Drawing Title
Arboricultural Impact
Our Lady of Victories
91 of 108

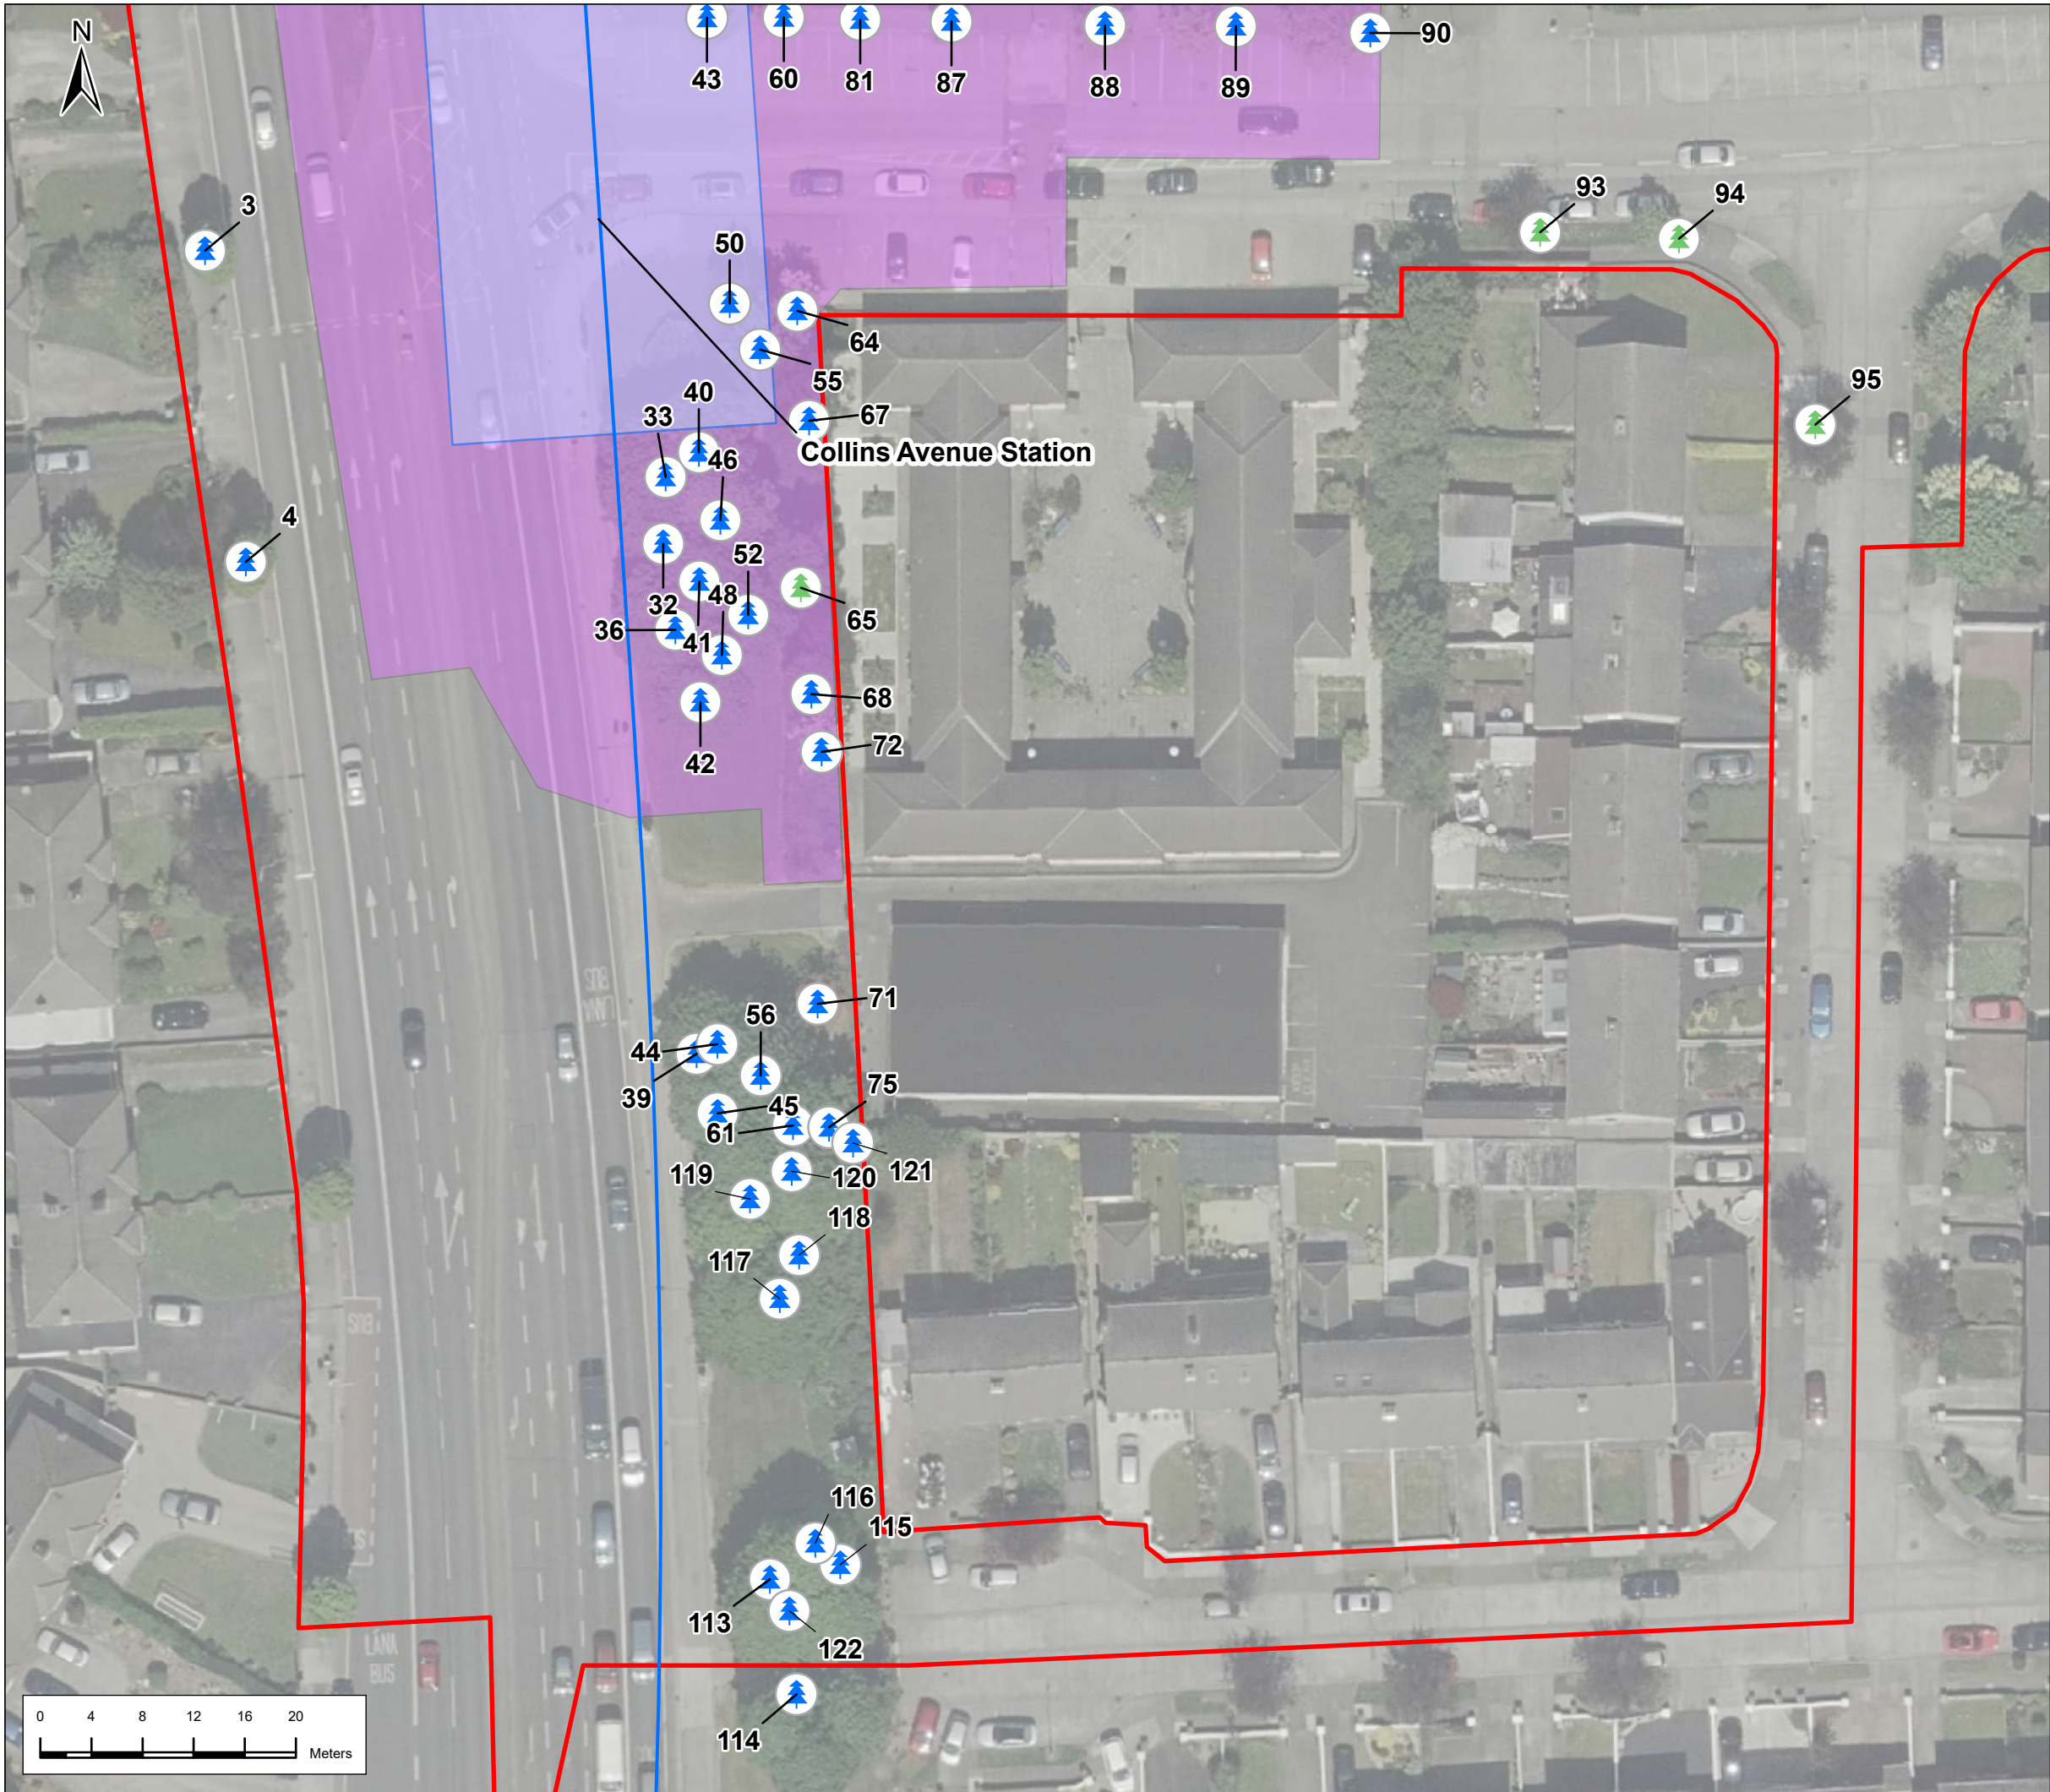
Submission No.			243/244/245/246	
Organisation Name or Name of Submitter			Our Lady of Victories GNS, BNS & JNS and Church	
Item No.	Section Ref.	Page No.	Observation Statement	TII Response
Proposed locations on Ballymun Road, relative to the operation and long-term viability of the Our Lady of Victories Schools				
15		6	The proposed addition of thousands of tonnes of concrete into the area so close to the school will mean that the water table will be affected (due to this project happening so close to the culvert of the river Wad) . This will cause flooding and destroy our approximately 100 mature trees on the campus. The flooding will , without a doubt, affect health and safety on the campus.	<p>As outlined in EIAR Appendix A18.5 Flood Risk Assessment (FRA), a new drainage scheme will be required to facilitate the construction and operation of the proposed Collins Avenue Station (Section 6.3.10).</p> <p>As noted in Chapter 18, Section 18.5.3.3, during construction temporary pumping of groundwater will be undertaken to permit construction of underground scheme elements. It also notes that the predicted impact from dewatering is considered temporary, imperceptible to not significant based on proximity to the Wad River culvert. Historical flooding of the River Wad was caused by a blockage of the Wad Bridge and insufficient capacity of the surface water drainage system of Ballymun Road (Table 4.2 Appendix A18.5). Both of those occurrences will be mitigated against. The discharge of any groundwater to surface water receptors will be subject to consent and controlled to ensure no adverse impact on flood risk. The elevation of the proposed overground infrastructure across the scheme and nature of surface strata as impermeable clay, means the above ground emergence of groundwater is highly unlikely. There are also no reports of groundwater flooding across the proposed Project . The risk of groundwater flooding to the scheme is therefore considered to be low and therefore there is no impact predicted on the trees in your campus. (Section 5.7 Appendix A18.5).</p>
